DECISION NOTICE

Application Ref: WA/98/21/PL

Removal of outdoor storage, including caravan and polytunnels and the erection of 7 No. units comprising of 12 offices and 3 workshops, associated parking, drainage and turning spaces (resubmission following WA/58/21/PL). This site is in CIL Zone 3 (Zero Rated) as other development.

Drawing title:
**Existing & Proposed Block Plans,
Location Plan**

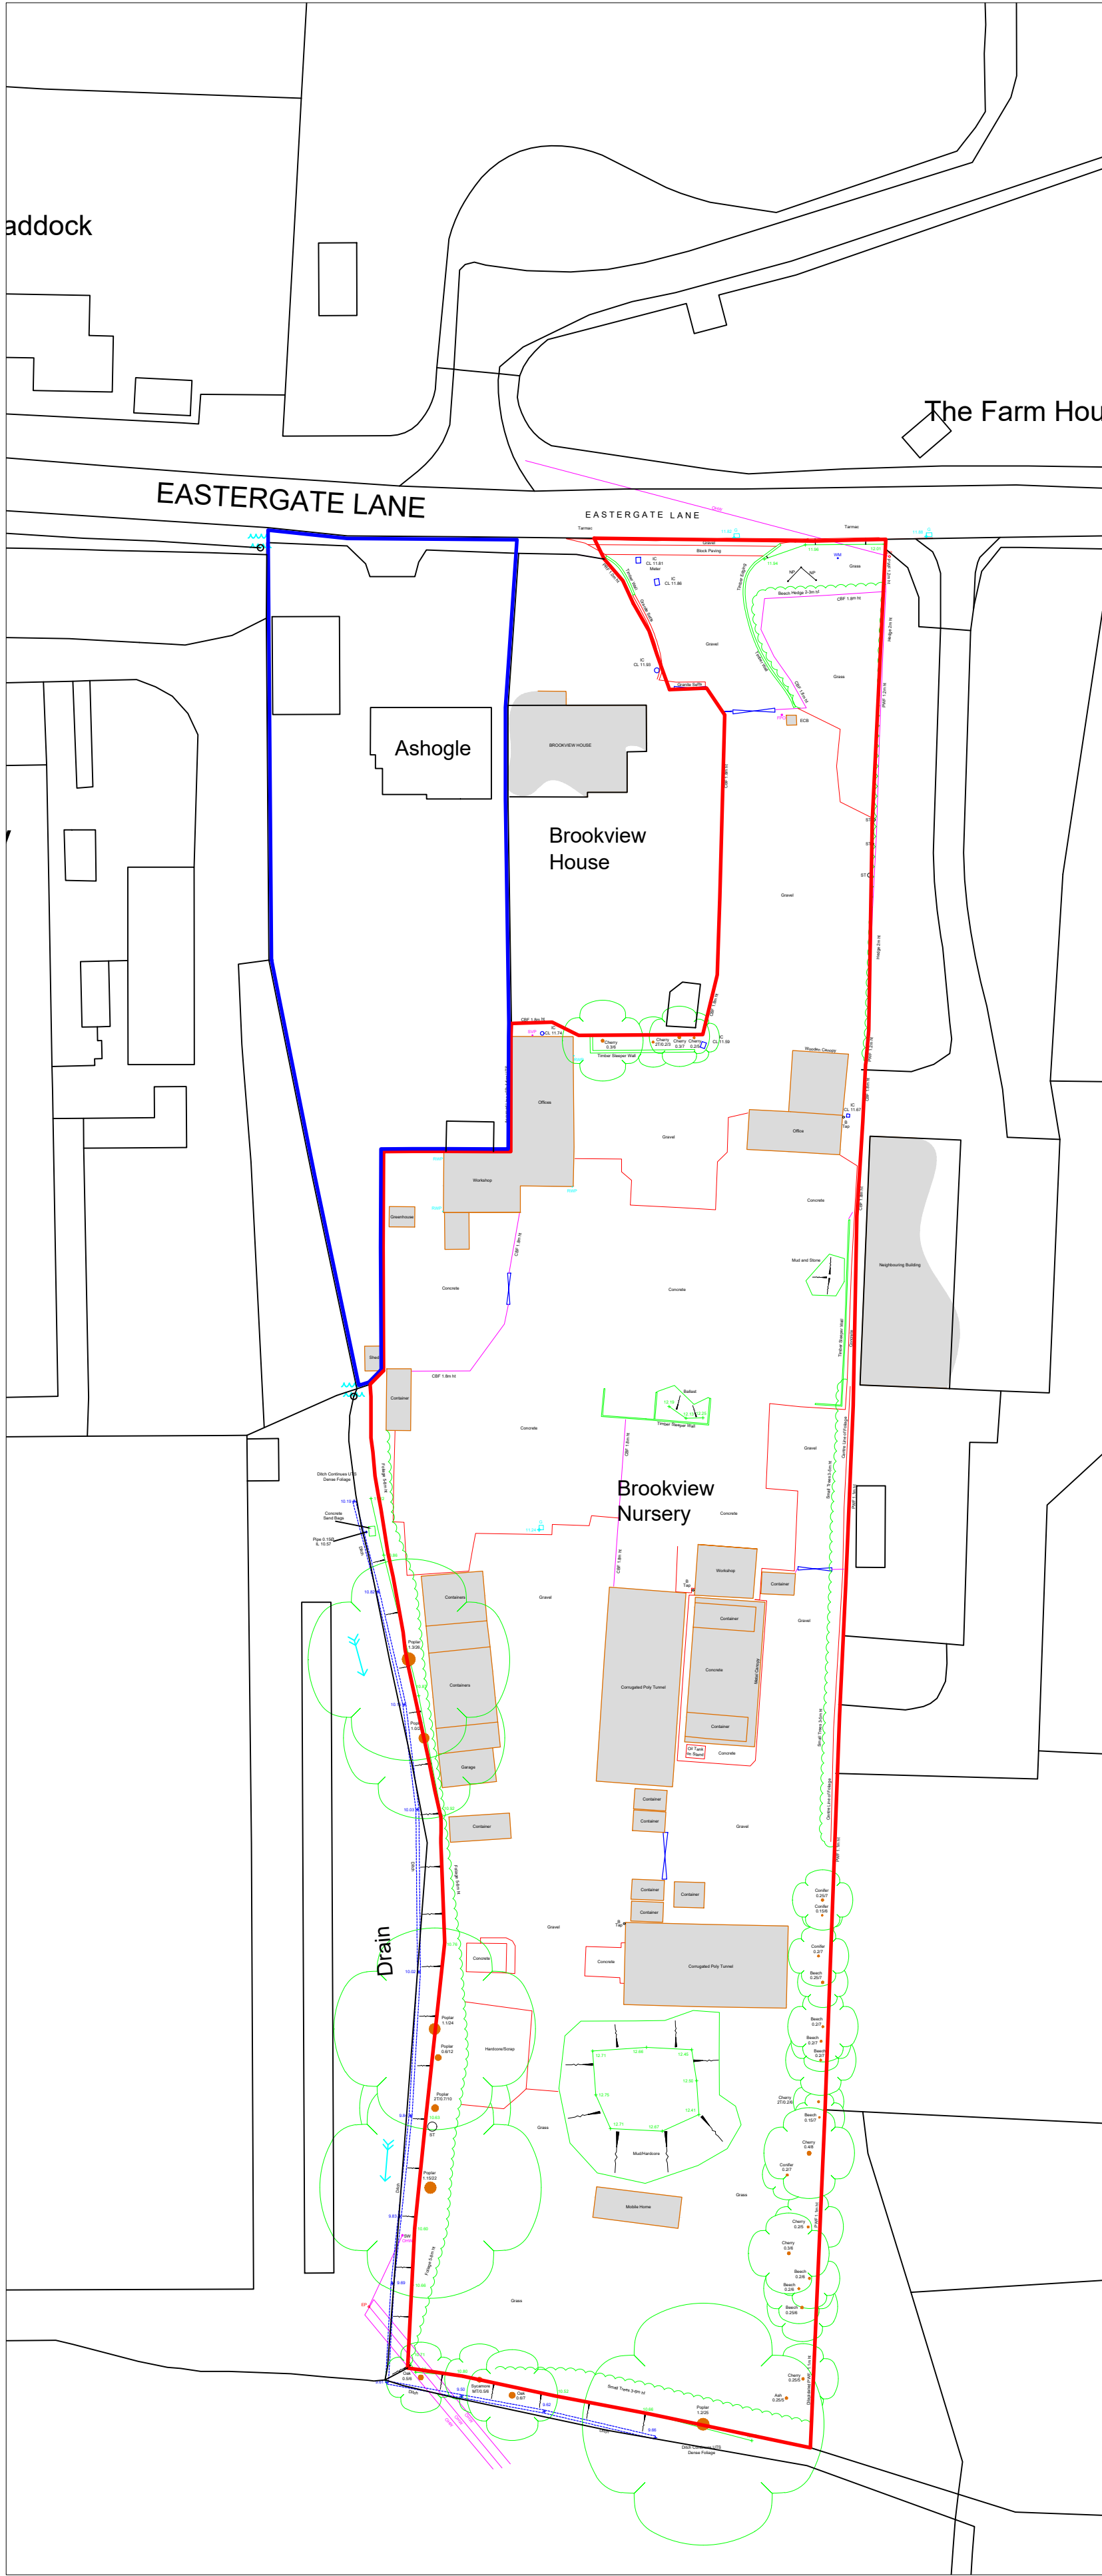
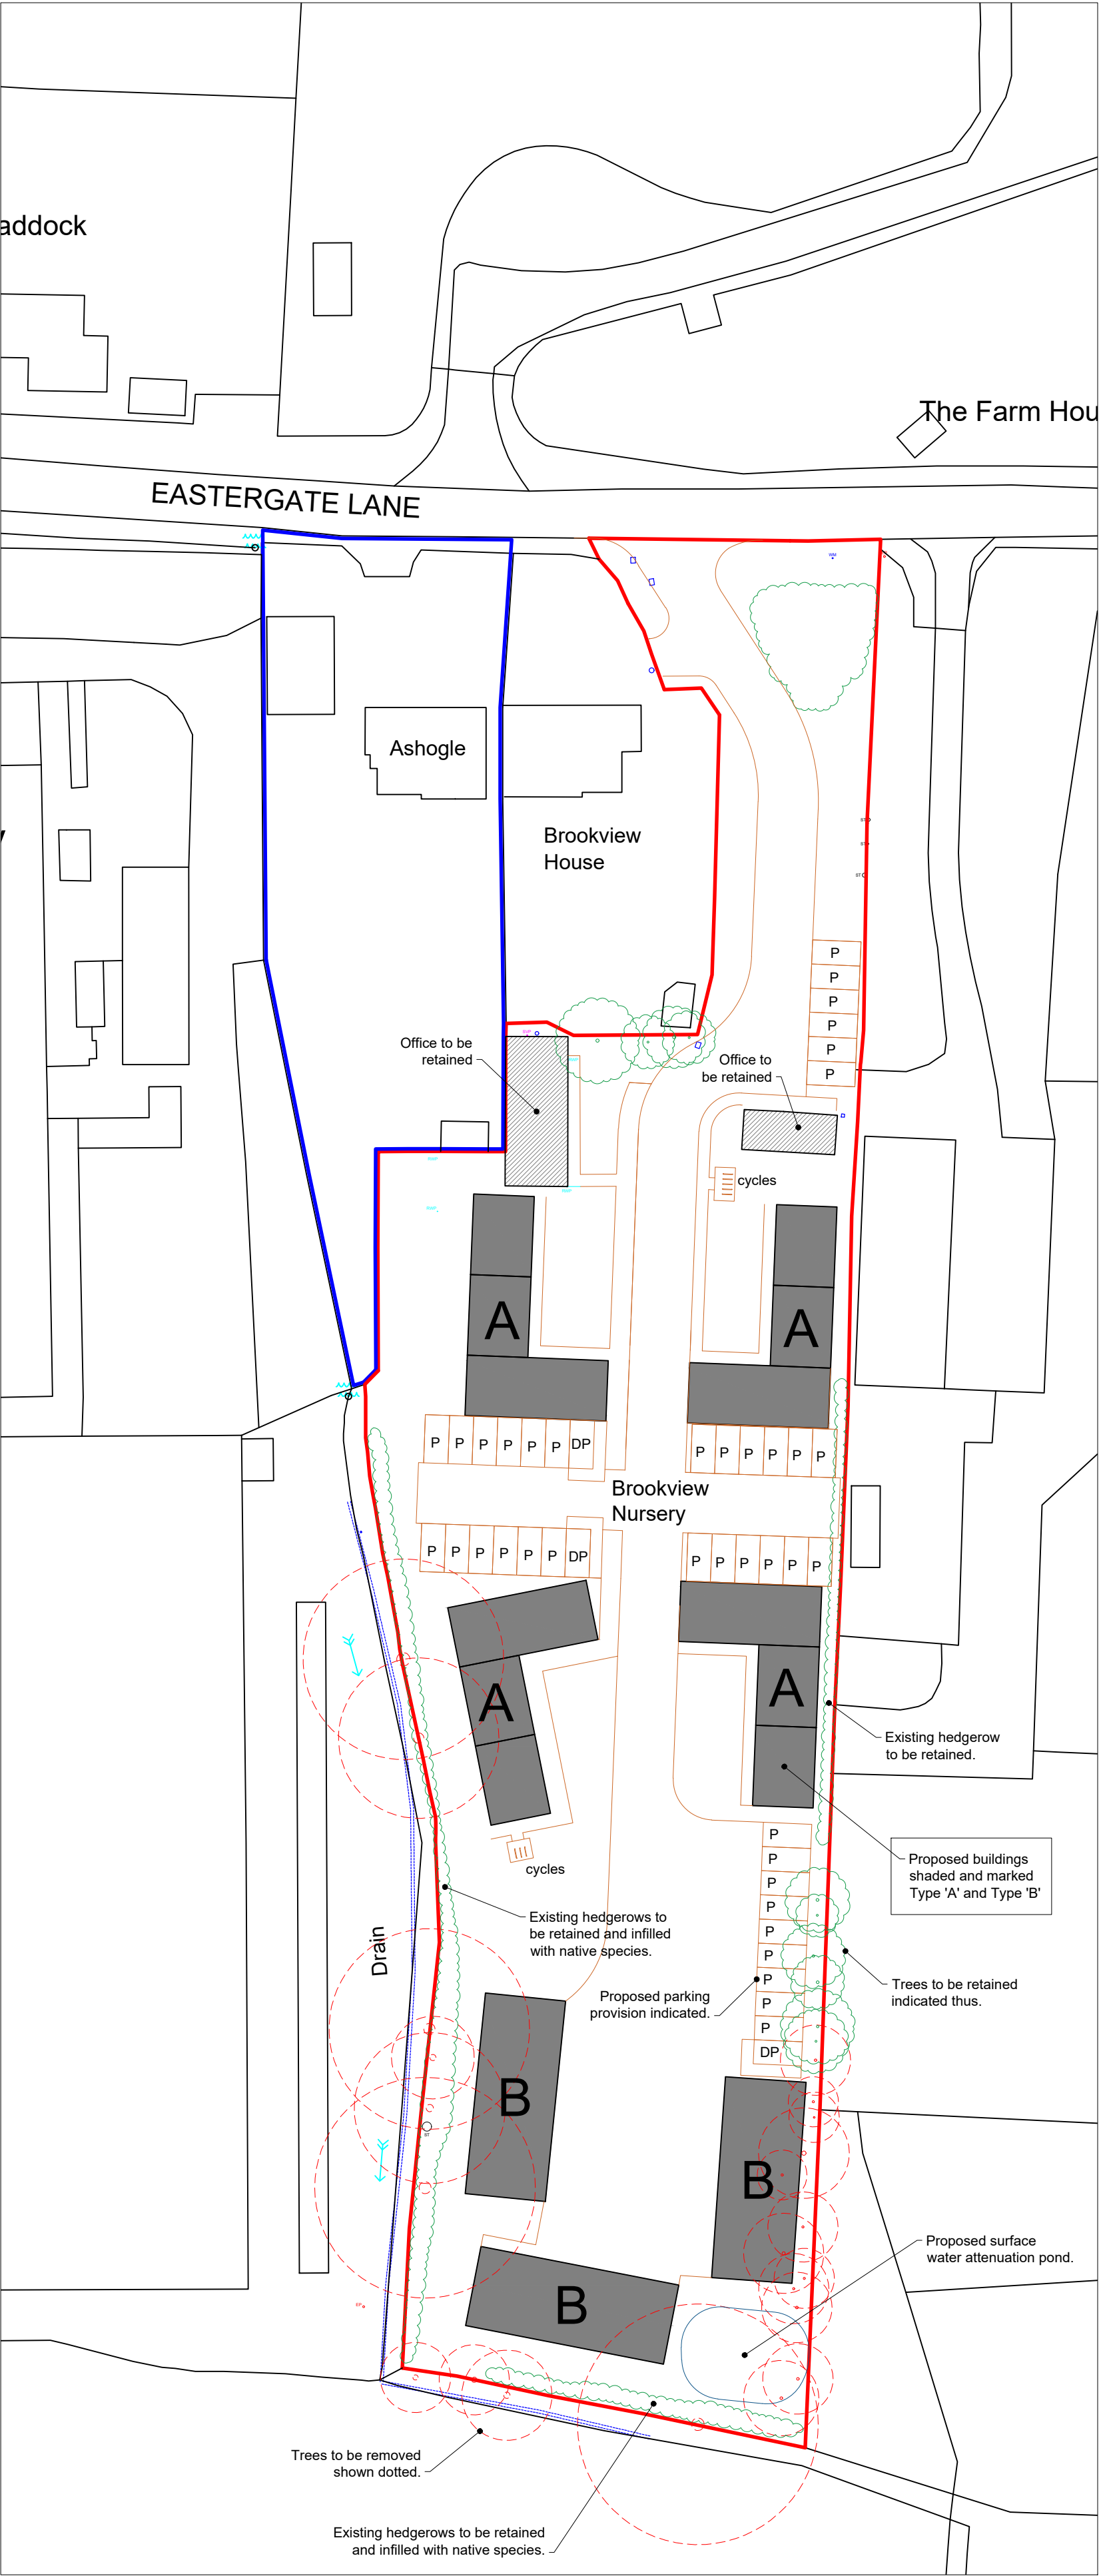
- 1 The supporting documents are collectively unclear as to which of the important trees on the site are to be removed but it is clear the layout will result in substantial and potentially damaging activity in the Root Protection Areas of the vast majority of retained trees. This combined with potential damage during construction, ground compaction and future pressure to prune or fell will result in clear harm to such trees and the contribution they make to the character of the area, the local landscape and to on-site ecology in conflict with Arun Local Plan policies ENV DM4, ENV DM5, D DM1 & LAN DM1, Walberton Neighbourhood Development Plan policies VE3 & VE10 2020 and the NPPF.

- 2 Given the discrepancies in the application regarding the impact on trees, it is not possible to determine whether the proposed development will result in any significant adverse effects upon the Singleton and Cocking Tunnels Special Area of Conservation, the bat species associated with that site or its functionally linked habitats (in respect of loss of foraging habitat and/or severance of commuting flight-lines). The proposal is therefore in conflict with Arun Local Plan policy ENV DM1 and Walberton Neighbourhood Development Plan policy VE10 2020.
